# COLORADO GEOLOGICAL SURVEY

**Subject: Redtail Ranch Subdivision (SP184), Preliminary Plan,  
Black Forest, CO; CGS Unique No. EP-18-0064 2**

Colorado Geological Survey has reviewed the Redtail Ranch resubmittal. Updated documents provided for our review included: Letter of Intent (N.E.S., December, 2018), Drainage Report (Classic Consulting, November 2018), Preliminary Plan (N.E.S., December 7, 2018), and Soils and Geology Report (RMG Engineers, Revised November 9, 2018).

REDTAIL RANCH PRELIMINARY PLAN

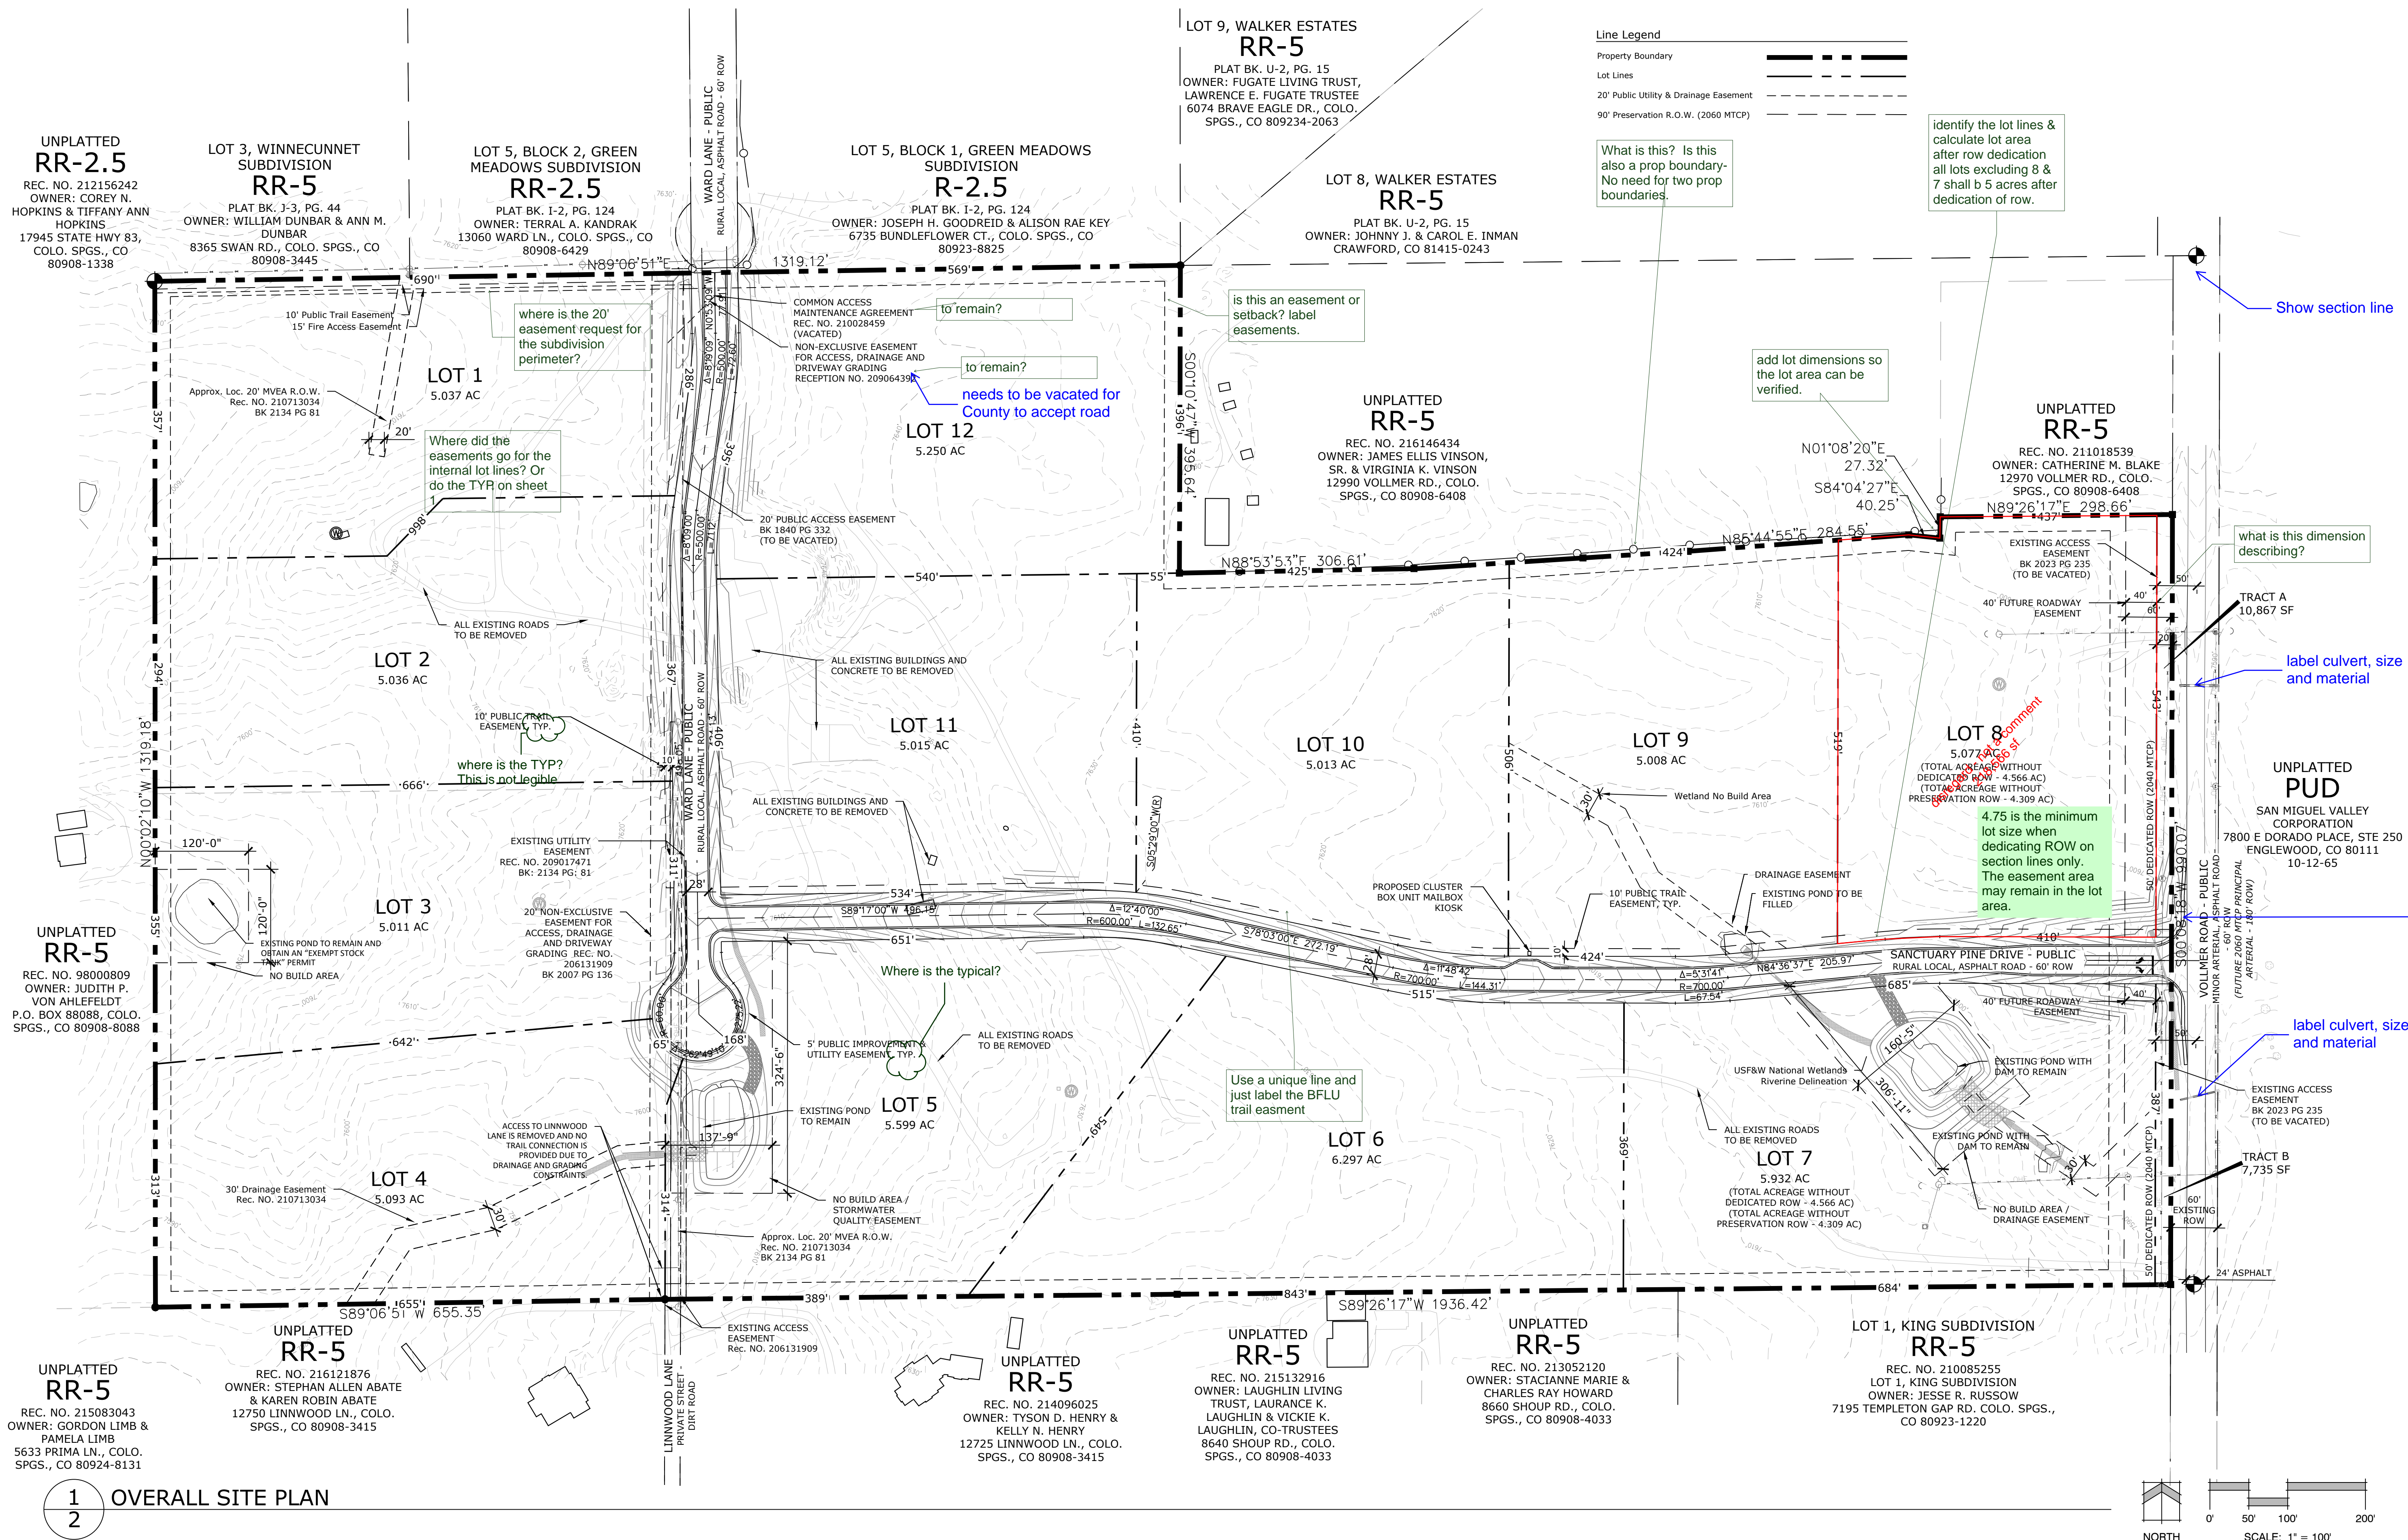
Preliminary Plan: Note 16 states: "*Constraints identified consist of Potentially Expansive Soils, Radon which is generally considered high in most of Colorado, Flooding and Surface Drainage, potentially Shallow Groundwater, and Erosion.*"

- CGS recommends that the geology and soils report provide a complete and clear summary of the geologic hazards and constraints actually identified at the site and mitigation planned for these conditions. This should include a discussion of the shallow bedrock constraint located at the site. The notes on the Preliminary Plan should be consistent with this summary.

- We recommend that the Preliminary Plan also depict these known septic field areas with notes on requirements for additional investigation and engineering should building be planned in these areas or label them as no-build areas.
- The Preliminary Plan should indicate that the natural drainage on Lot 4 is a no-build area.
